## BUILDING CODE OF AUSTRALIA 2016 REPORT

### PROPOSED COSTCO DEPOT, OAKDALE SOUTH INDUSTRIAL ESTATE, KEMPS CREEK, NSW 2178

Report Ref: 16-207694\_Costco\_OakdaleDepot\_BCAREportR03\_230317

Date: 23 March 2017

1 SITE PLAN
1:100

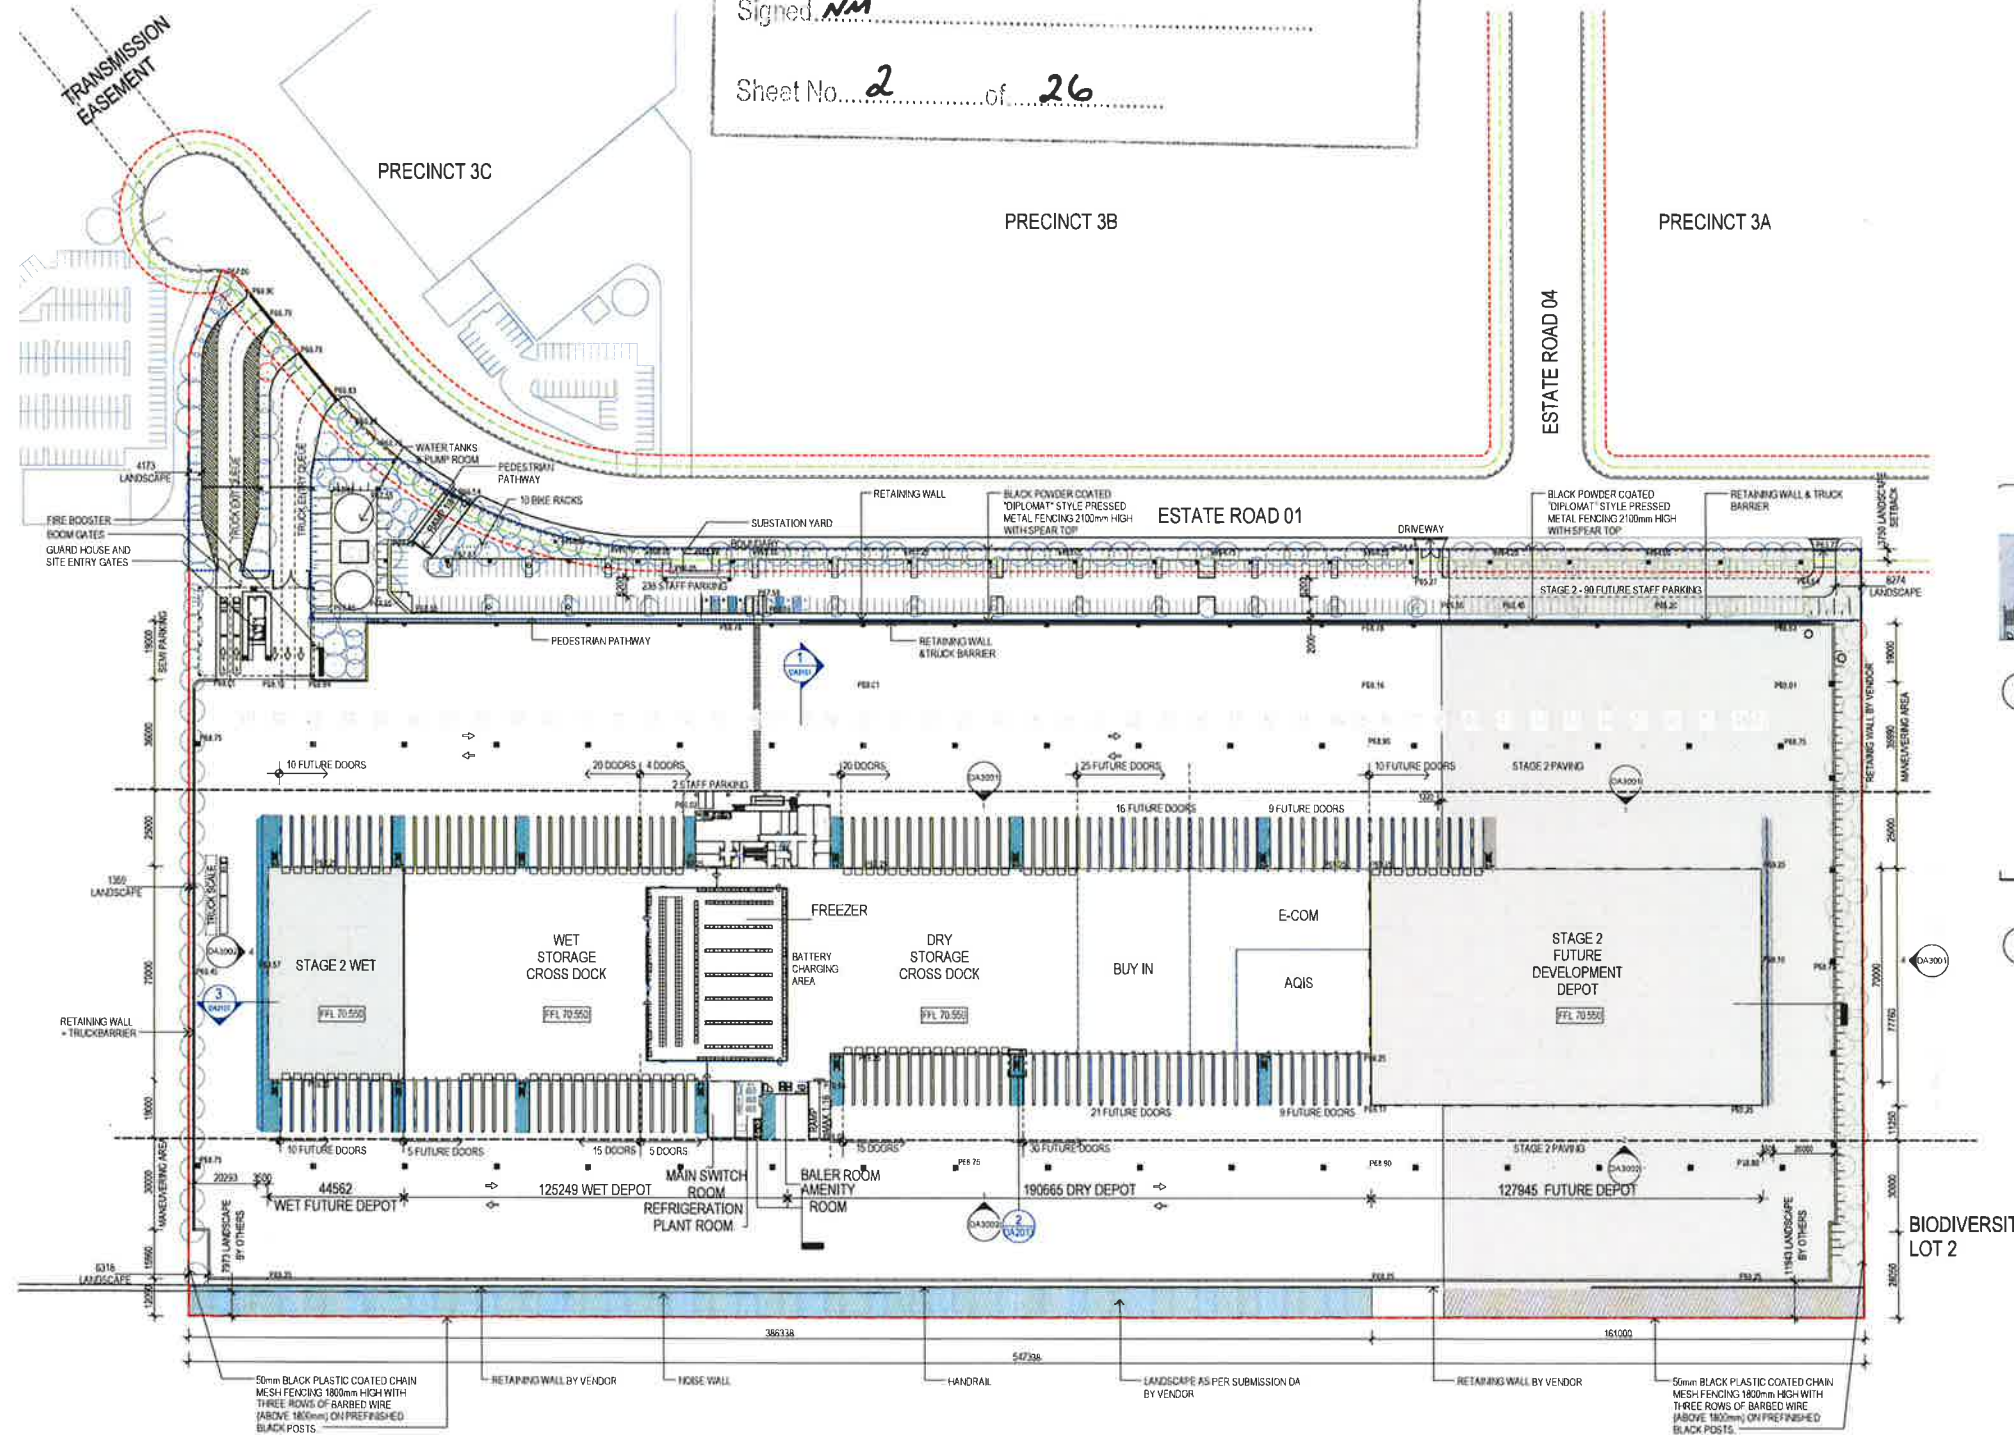
No.	Issue	DtS Clause	Performance Requirement (A0.7)	Description
1.	Perimeter access to be greater than 18m from the building in some areas	C2.4(b)	CP9	Worst case shows the 6m vehicular access path being situated approx. 50m from the Southern facade of the Stage 1 development.

8.	The booster is not deemed to be located at the boundary of the site.	E1.3	EP1.3	AS2419.1-2005 Clause 7.3(d)(i) requires the booster to be located at the boundary of the site and be within sight of the main entrance of the building. The proposed booster location is setback from the boundary, along the vehicular path way, by approximately 85m, this is not deemed to be located at the boundary of the site.

3 GUARD HOUSE FLOOR PLAN
1:100

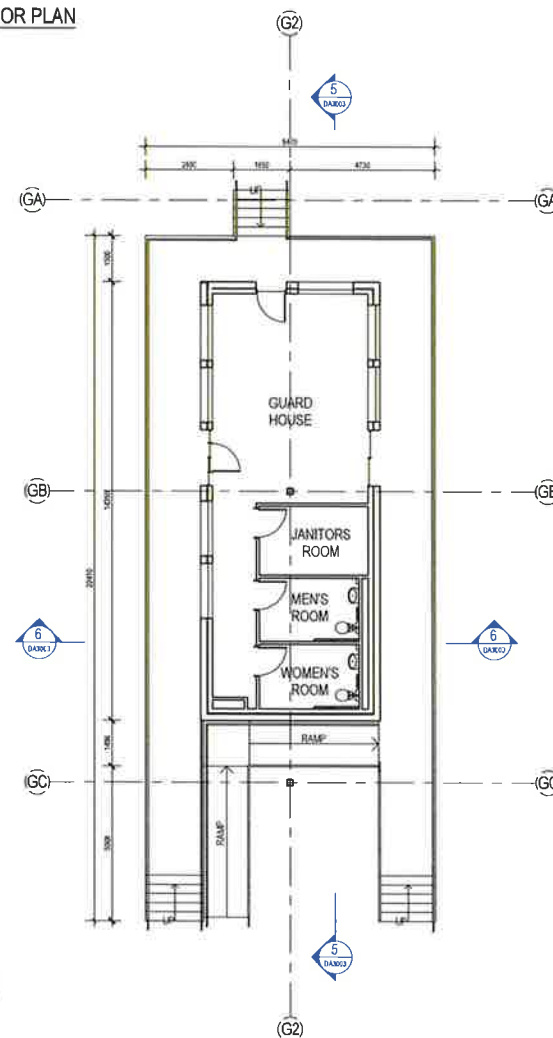
There is also a 72m<sup>2</sup> guards house located at the vehicular entrance of the site; this building is a Class 5 building of Type C construction.
